Remove existing garage & erect a single storey side extension annexe for a dependent relative.

Fortunes Gate 1 First Avenue, Ancton Middleton-on-Sea

Ref Planning Application M15/15/HH

Proposed Front Elevation

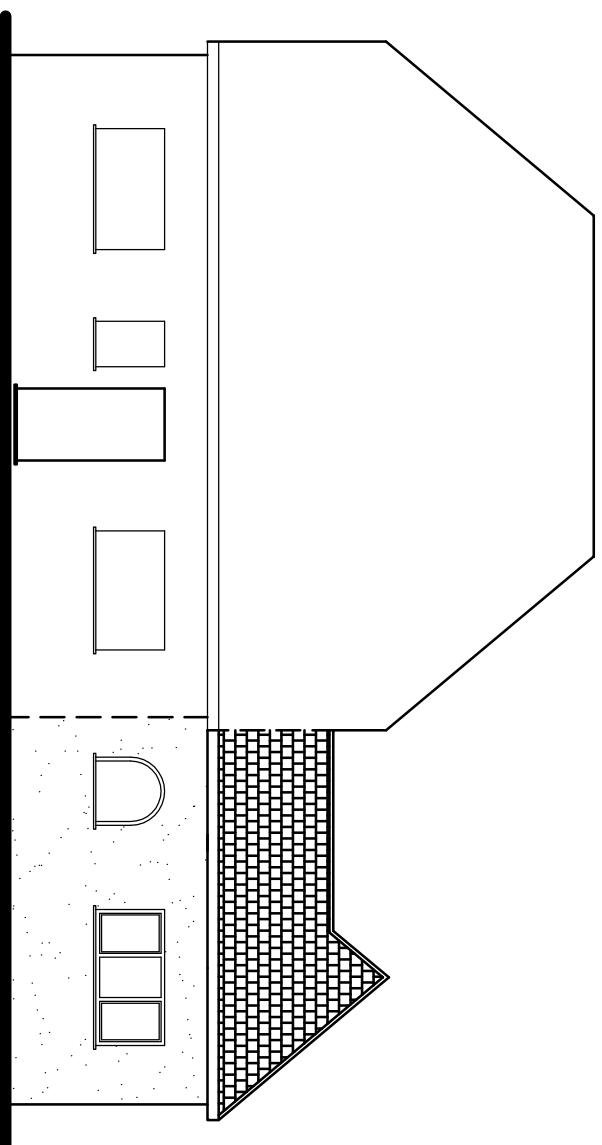
2 We OBJECT to the Front Elevation roof line of the proposed extension as it does not blend in with the architectural style of the main house AND is not in keeping with the character and style of the rest of the properties in the road and surrounding Estate.
